07/03/00 pre-constructum - talked about deck rail ht and guards + handrails and requirements - setback not needed - same footprint - no egress windows in kitchen - told contractor about needed inspections including permits needed for electrical & plumbing. Historical District - OK by them. TM

**CITY OF PORTLAND, MAINE**  
**HISTORIC PRESERVATION COMMITTEE**

Re: 52 Bowdoin; Replacement of rear bay

On May 3, 2000, the City of Portland's Historic Preservation Committee voted 6-0 (Pitman absent) to approve your application for a Certificate of Appropriateness. Approval is for replacement and expansion of an existing rear bay on the east elevation of 52 Bowdoin Street.

Proposed Changes

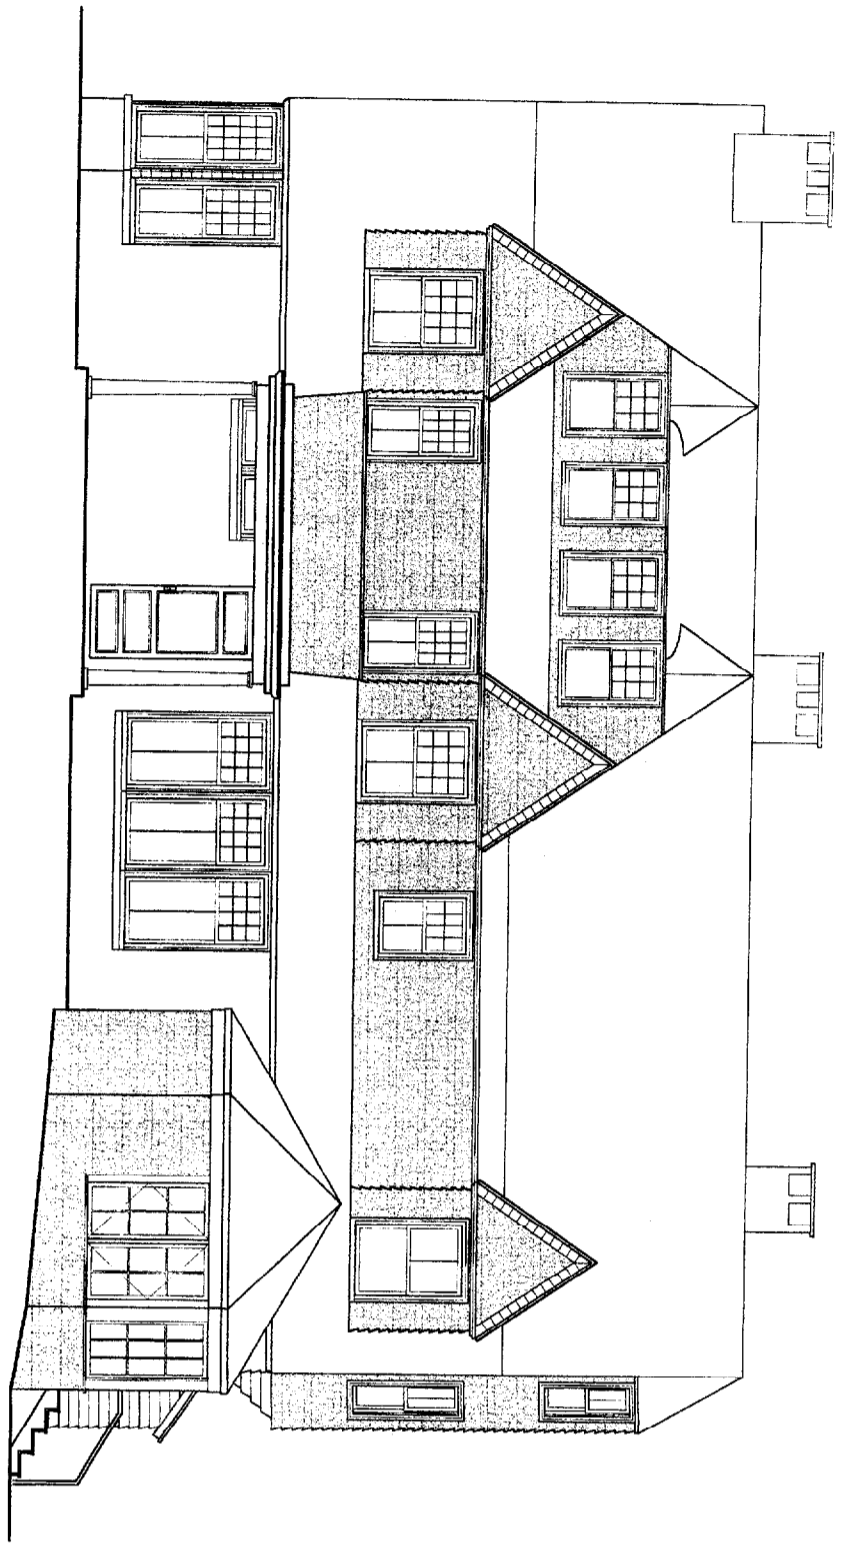
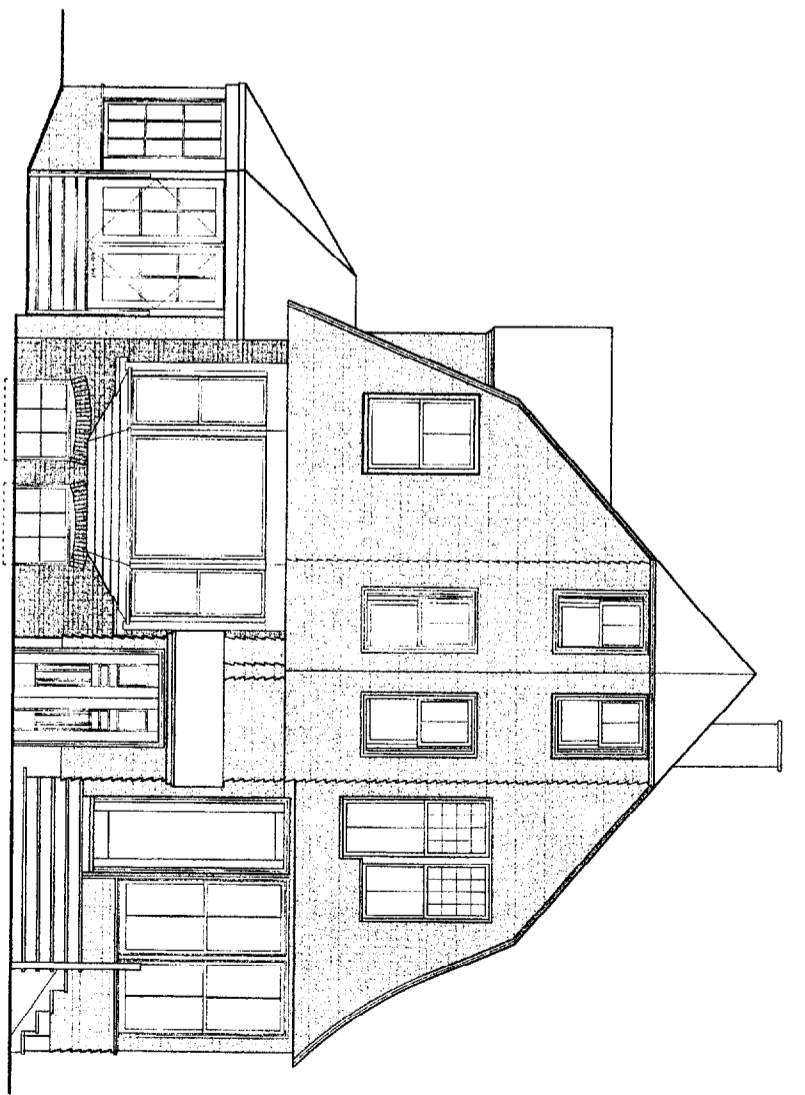
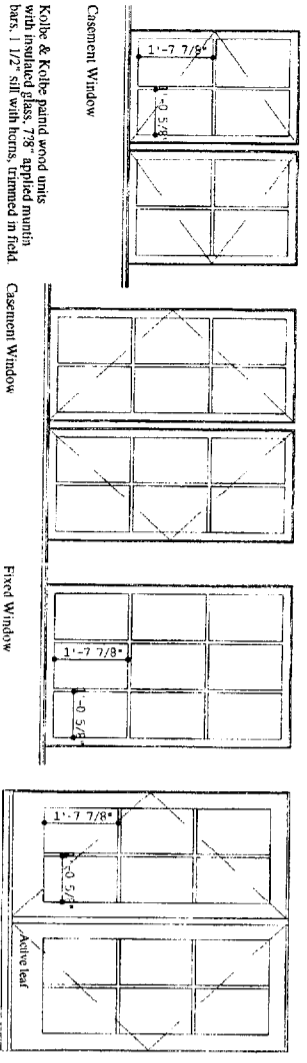
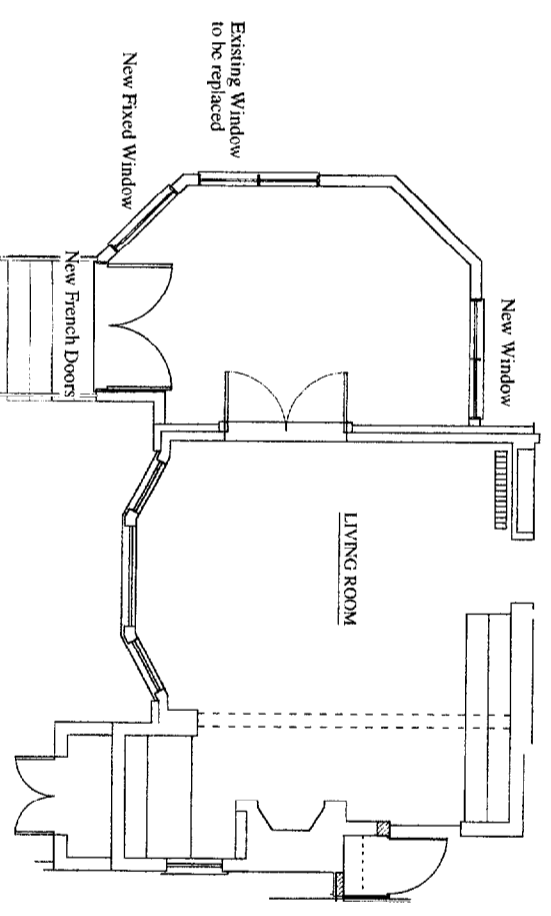
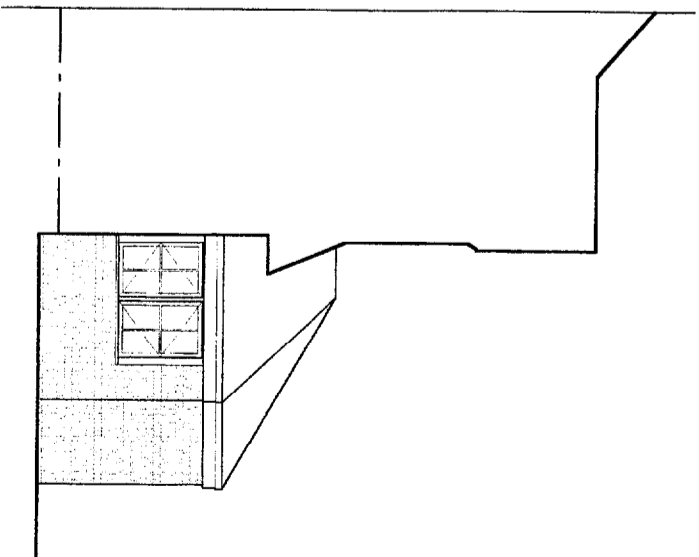
- \* That an additional course of shingles or trim board be added at the base of the proposed bay to bring it closer to grade level.
